Jane Tucker**From:** Manchester, Sarah [Sarah.Manchester@lancashire.gov.uk]**Sent:** 25 July 2011 12:47**To:** Sarah Westwood; planning**Subject:** application 3/2011/0498 The Eaves

**Application: 3/2011/0498****Proposal: Demolition of all buildings on the site (existing house, kennels and various outbuildings) and erection of a new dwelling incorporating a Bed and Breakfast Business.****Location: The Eaves Pendleton Road Wiswell Lancashire BB7 9BZ**

drawing title: PROPOSED SITE PLAN

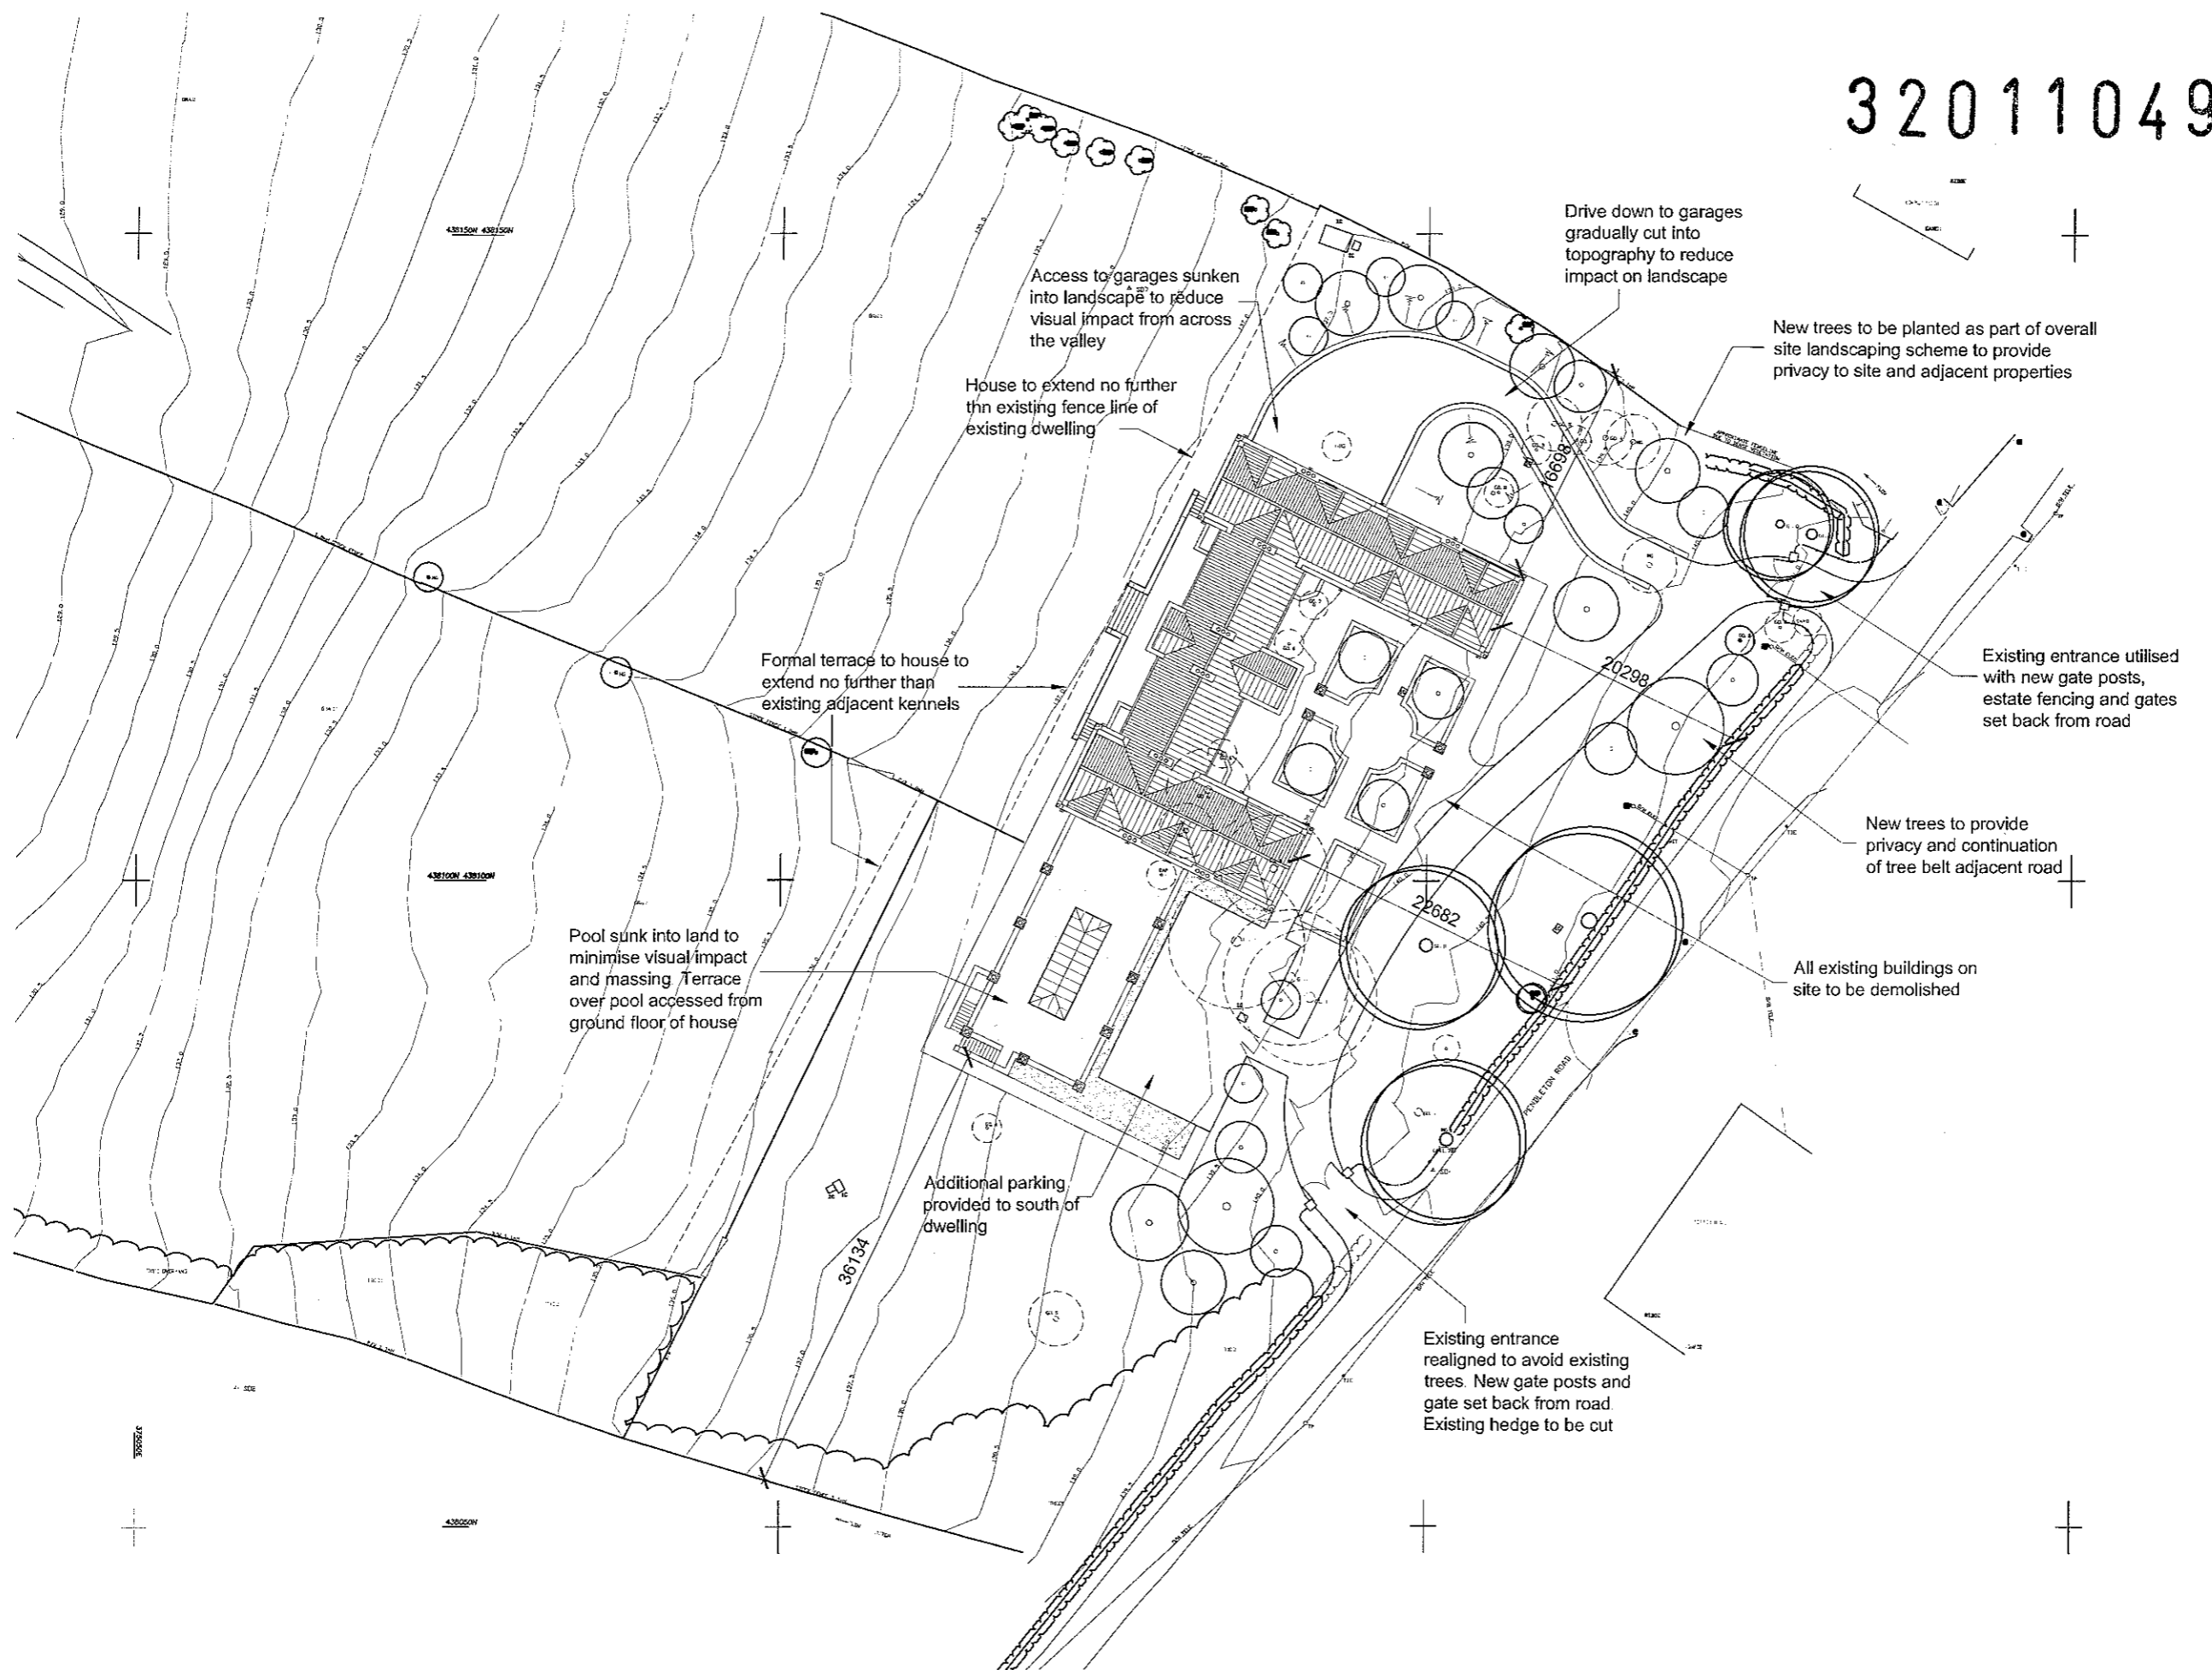
- No site clearance, site preparation or development work shall take place until a landscaping scheme has been submitted and approved in writing by Ribble Valley Borough Council in consultation with specialist advisors. The approved scheme shall be implemented in full. The scheme shall demonstrate adequate replacement tree planting to compensate for the loss of trees, and shall also demonstrate maintenance and enhancement of habitat connectivity.

- All trees being retained within or adjacent to the application area will be adequately protected during and after construction. Existing guidelines (e.g. BS5837: 2005 *Trees in relation to construction - Recommendations*) will be adhered to.

The ecology report notes that mature ash, sycamore and large-leaved lime to the front of the property had features suitable to support roosting bats, although no obvious signs of bat occupation were noted. It appears that these trees would be retained, and therefore there should be no impacts on bats or bat roosts as a result of these proposals. Obviously, if tree felling does become necessary in the future, trees will need to be reinspected by a suitably experienced bat surveyor for the possible presence of bats to ensure that offences are not committed.
